From: Bloomer, David <David.Bloomer@lancashire.gov.uk>
Sent: 20 June 2017 08:41
To: Robert Major
Cc: LHS Customer Service; planning
Subject: app3/2017/0489 Lyme House Farm Chipping

Dave Bloomer
Highways Development Control
Lancashire County Council

Drawing title
Proposed Site Plan

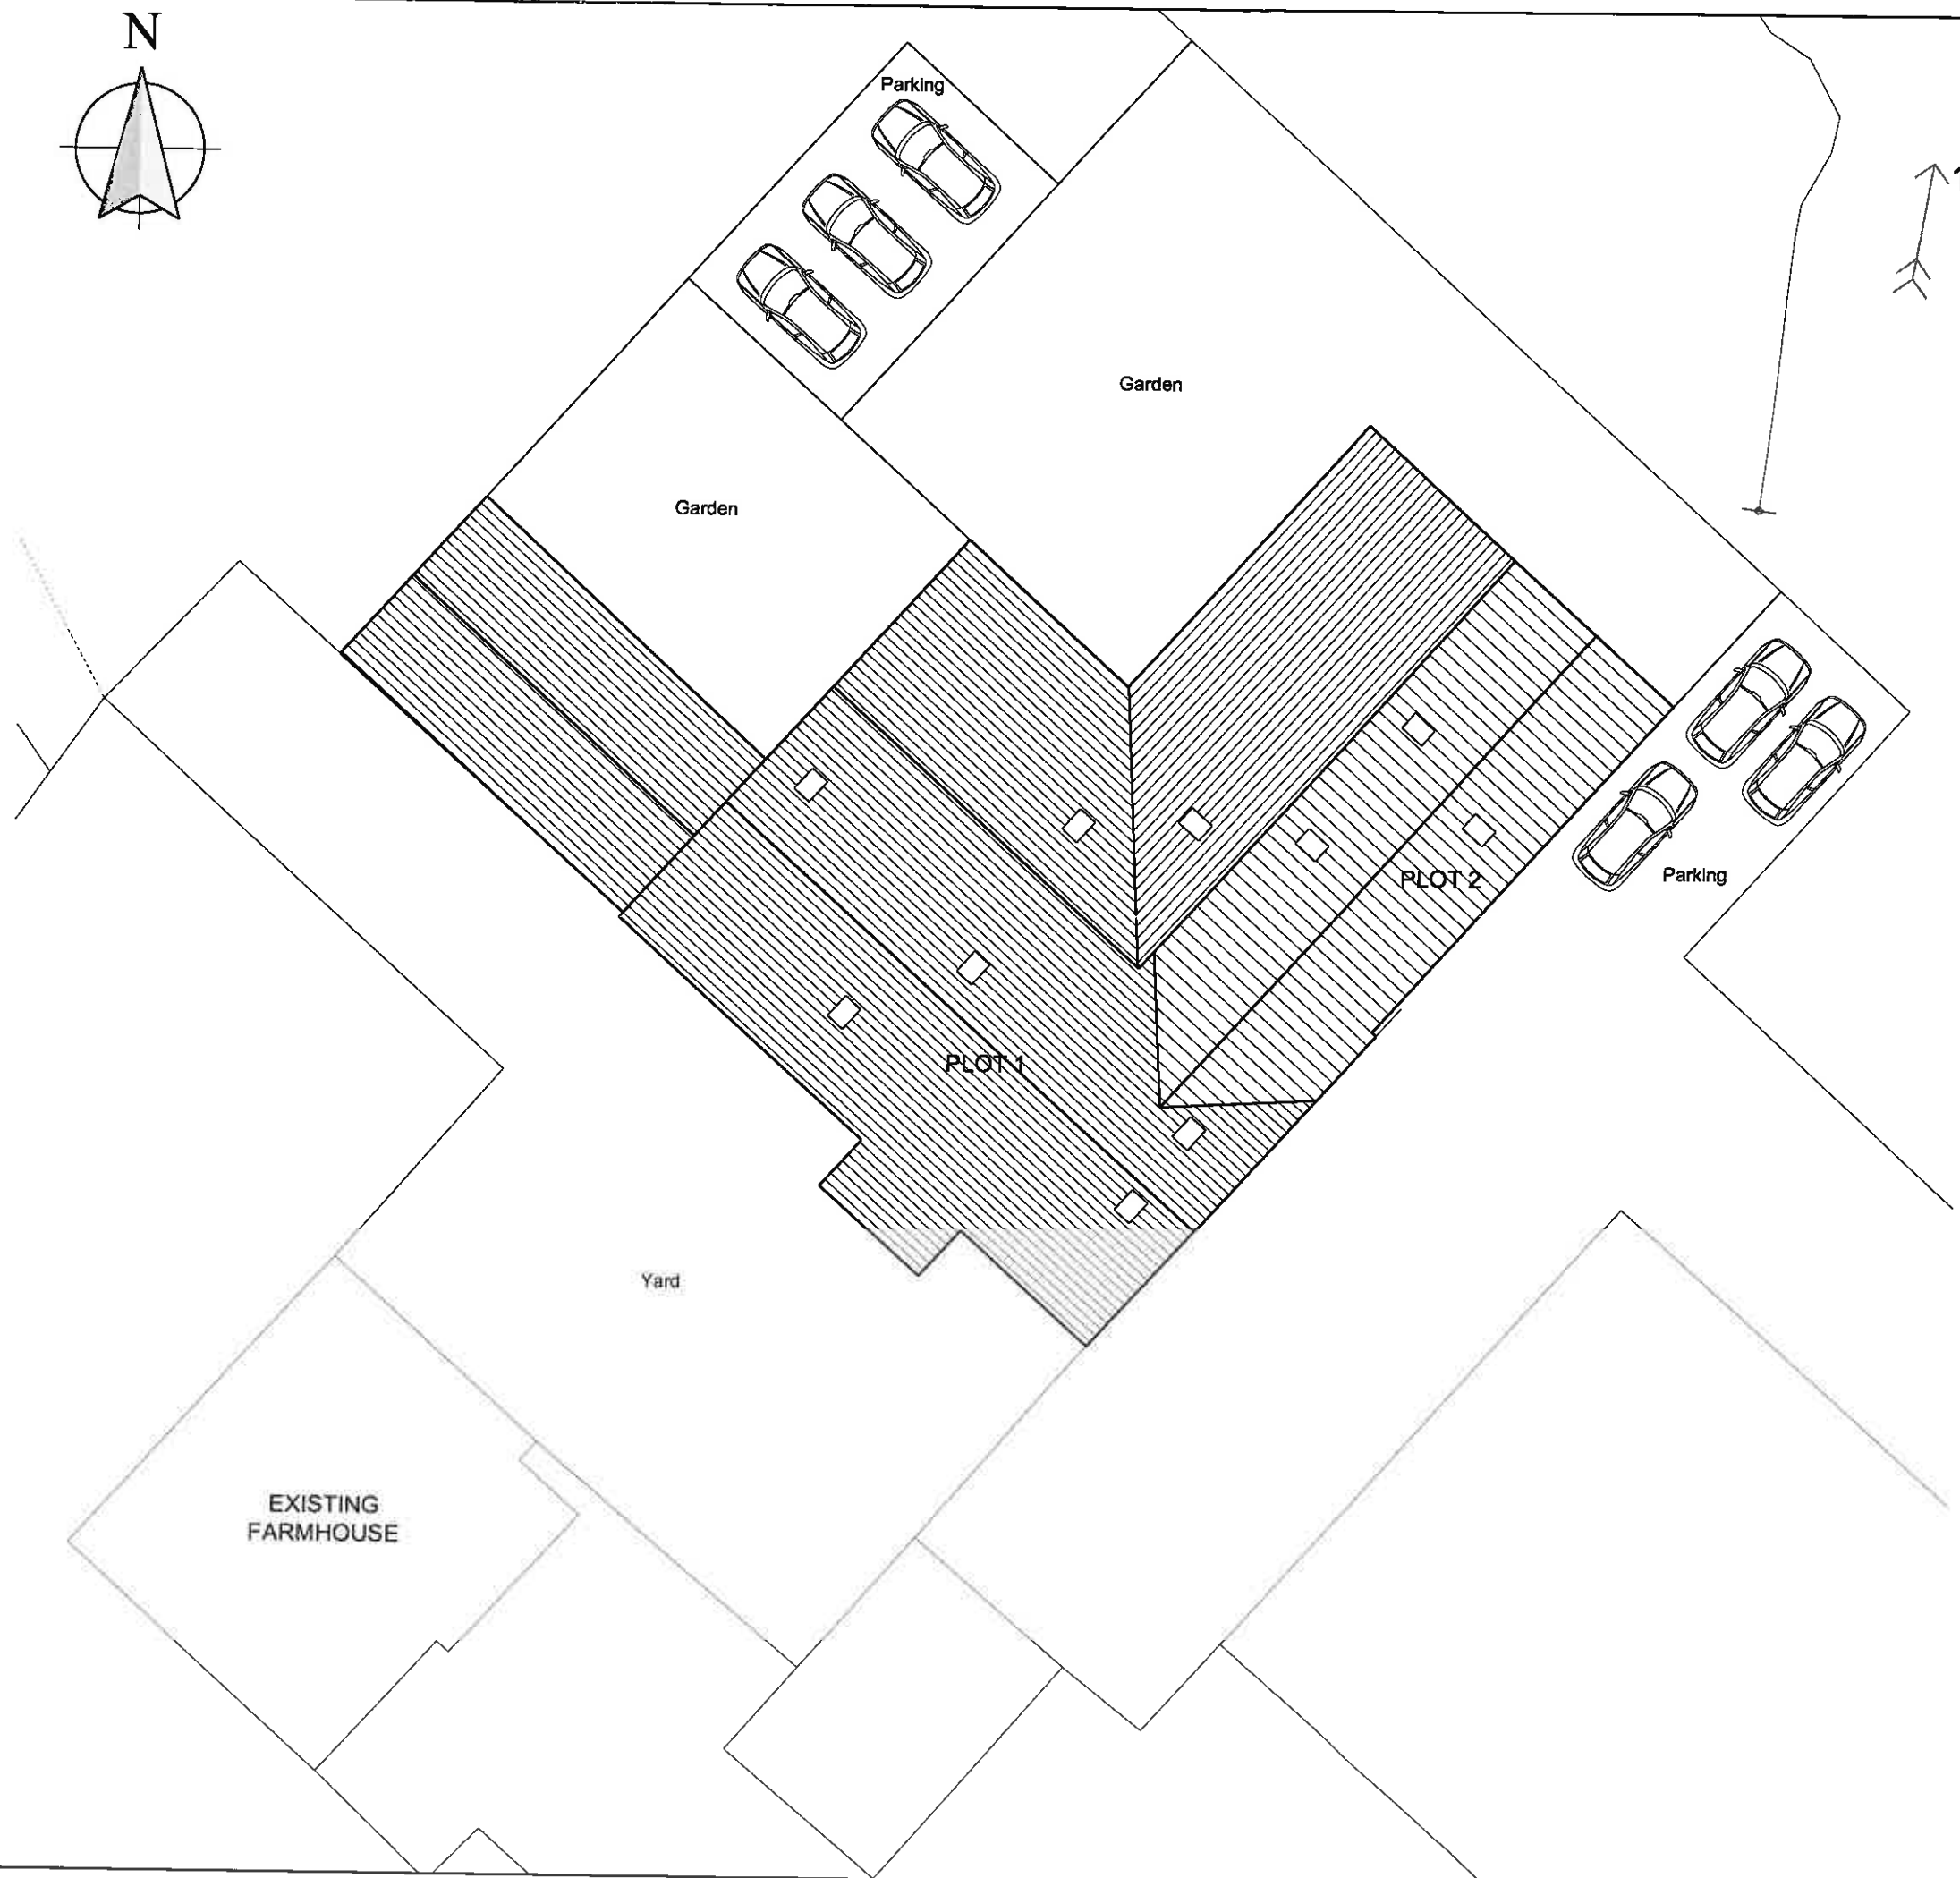
Whilst I would raise no objection to the proposal on highway grounds there will be an increase in vehicle movements along the access which has a restricted width and will not allow 2 vehicles to pass therefore I would require the formation of 2 passing places along the length capable of accommodating a tractor and trailer combination. These would be located within the site close to the site entrance and half way along the access
